From: Hebe Smith
Sent: 05 December 2025 11:02
To: Planning.Responses
Subject: FW: Snetterton, West Walberton Lane, Walberton, West Sussex. BN18 0QS - SURFACE WATER DRAINAGE WA/33/23/DOC
Attachments: P1913-BAK-XX-XX-DR-0500 P11.pdf; Action Sheet v6 WA-11 v2.docx

From: [REDACTED] >
Sent: 05 December 2025 10:54
To: Hebe Smith <Hebe.Smith@arun.gov.uk>; Sarah Burrow <Sarah.Burrow@arun.gov.uk>
Subject: Snetterton, West Walberton Lane, Walberton, West Sussex. BN18 0QS - SURFACE WATER DRAINAGE WA/33/23/DOC

Re - Snetterton, West Walberton Lane, Walberton, West Sussex. BN18 0QS - SURFACE WATER DRAINAGE WA/11/25/DOC

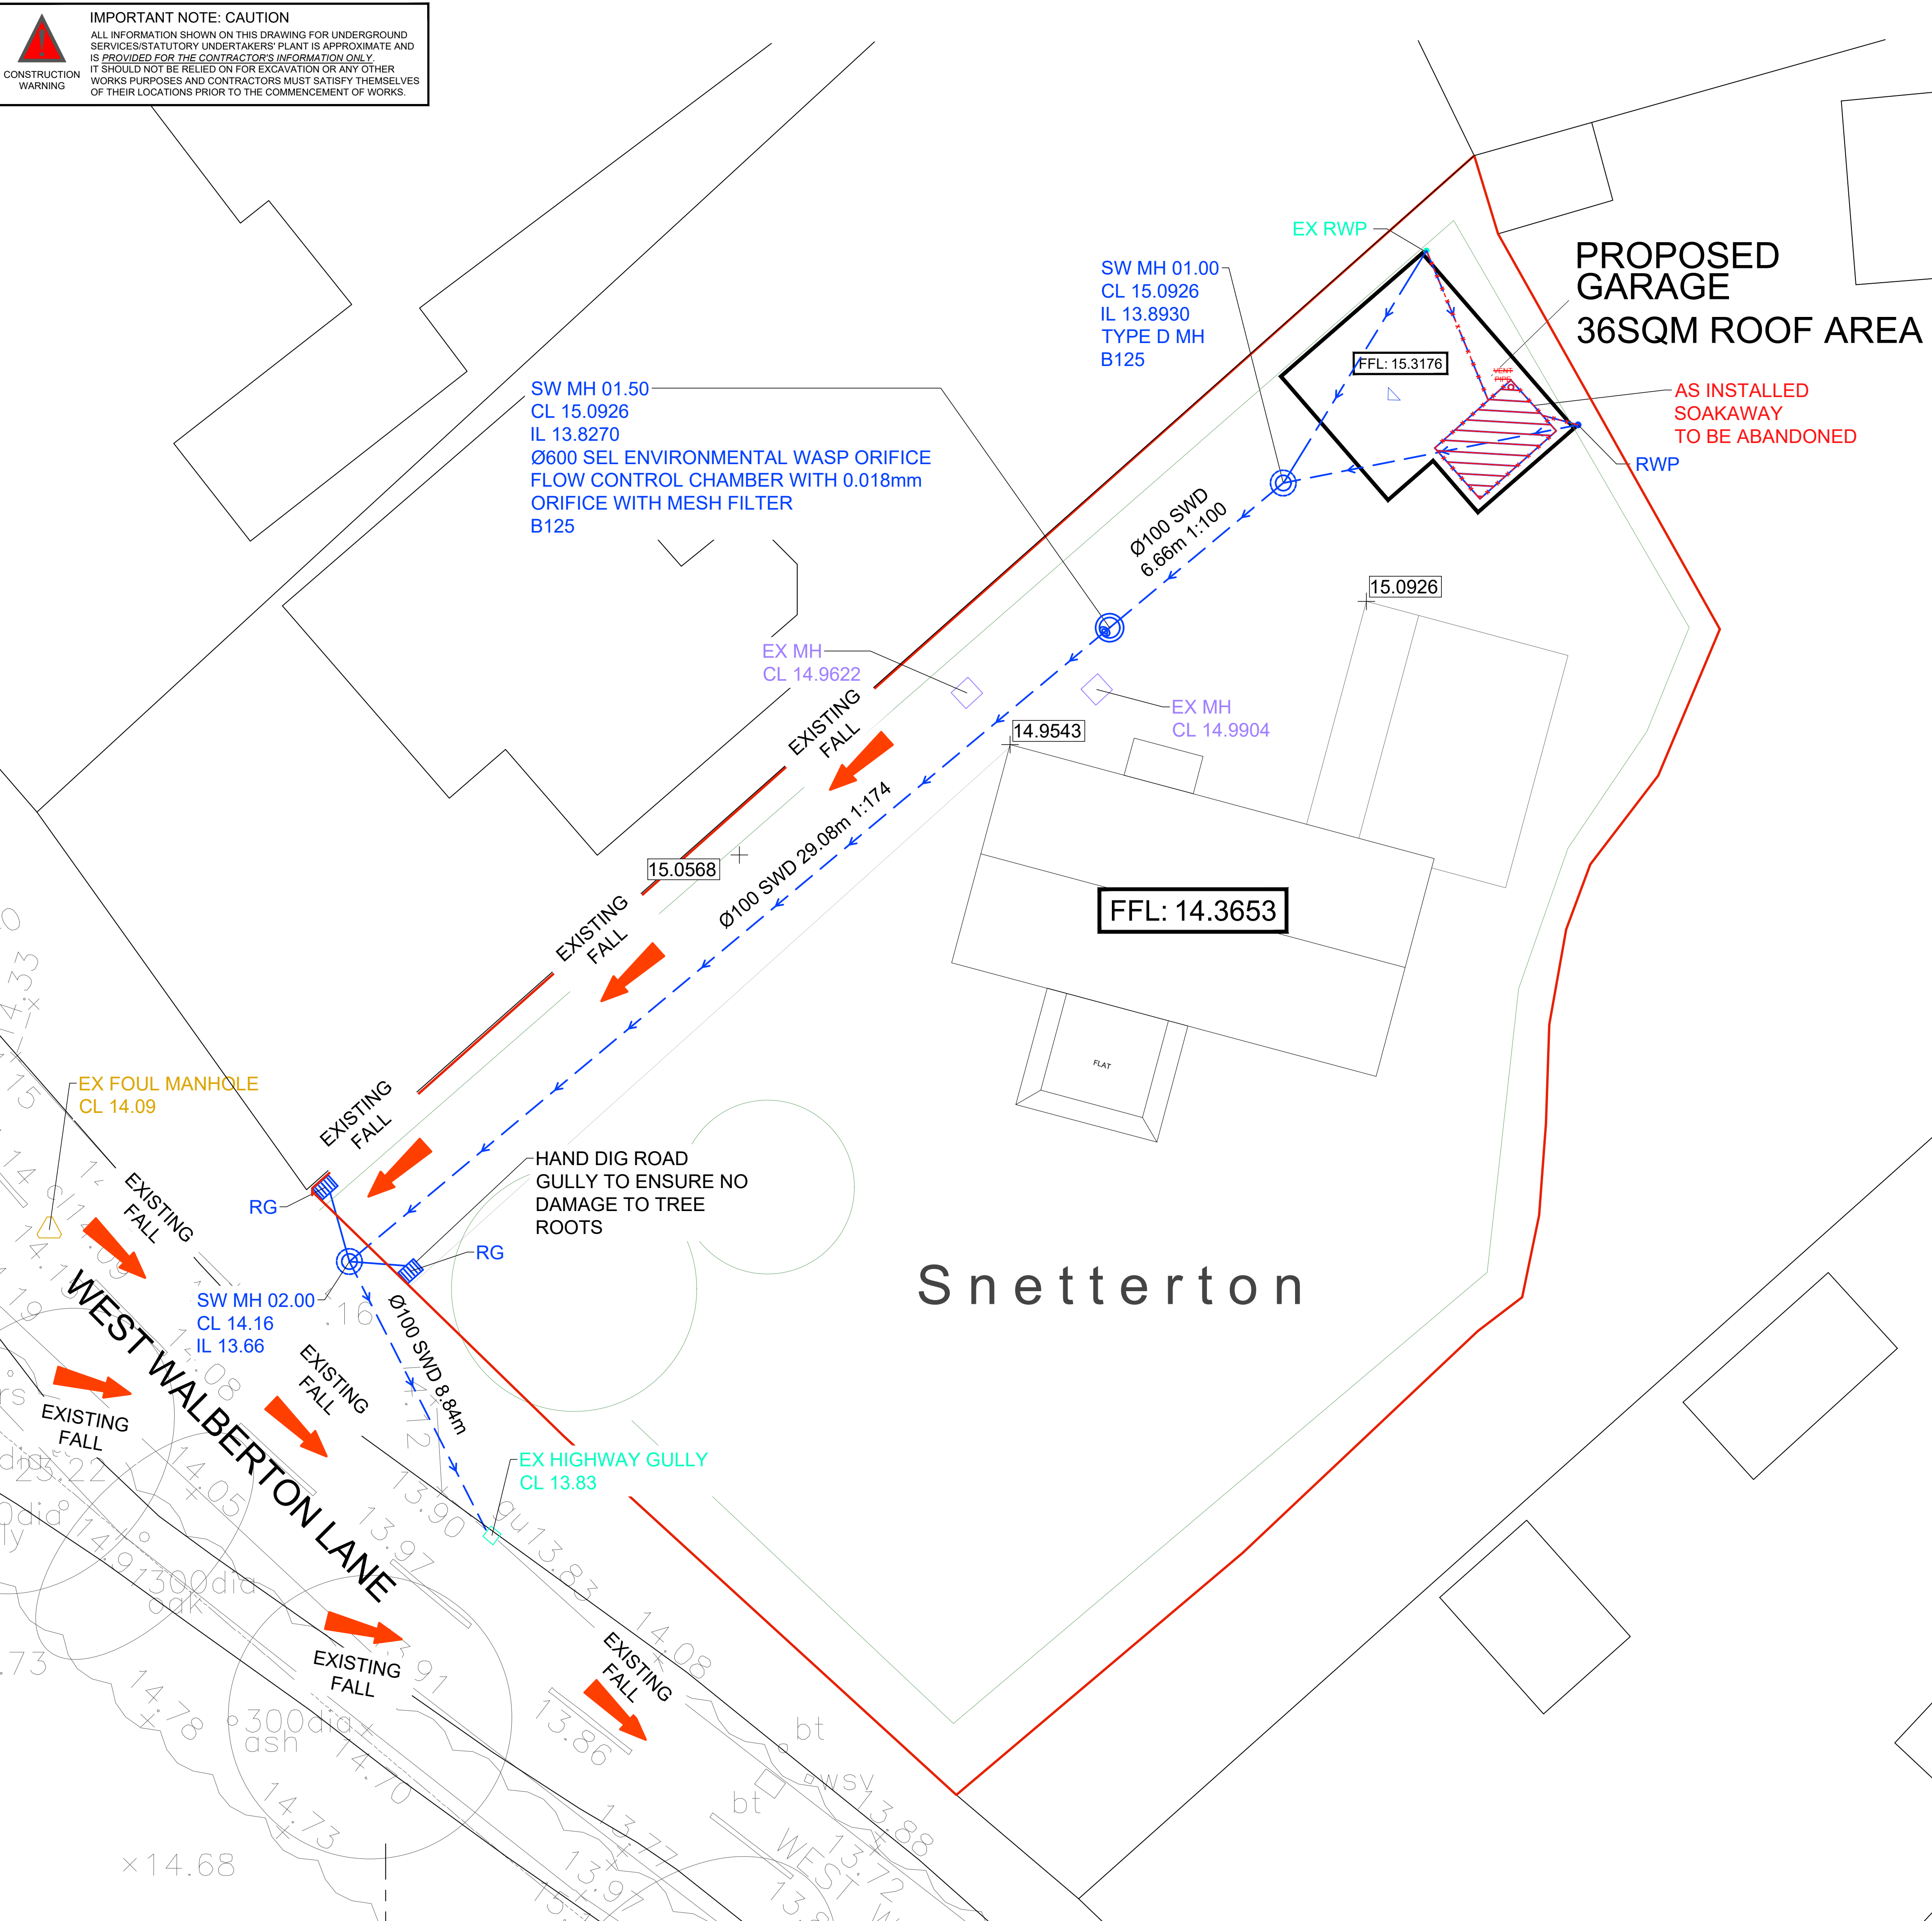
Your current drawing, submitted to ADC, shows your proposed connection being made into the existing road gully connection, this is not what was shown on your original drawing.

Your connection should be made direct into the gully, which should be reconstructed as a new catchpit gully to accept the connection.

For your information, I have attached details that show our standard detail for a catchpit gully (Type RG2, WSCC-SD1-0500-025).

This allows the flow control to connect to the pipe rather into the road gully.

EXISTING ROAD GULLY TO BE
REPLACED WITH NEW WSCC BRICK
GULLY / CATCHPIT TYPE RG2
IN ACCORDANCE WITH STANDARD
DETAIL WSCC-SD1-0500-025 REV C1
CL 13.830
IL 13.280 INCOMING 150Ø
IL 13.280 OUTGOING 150Ø
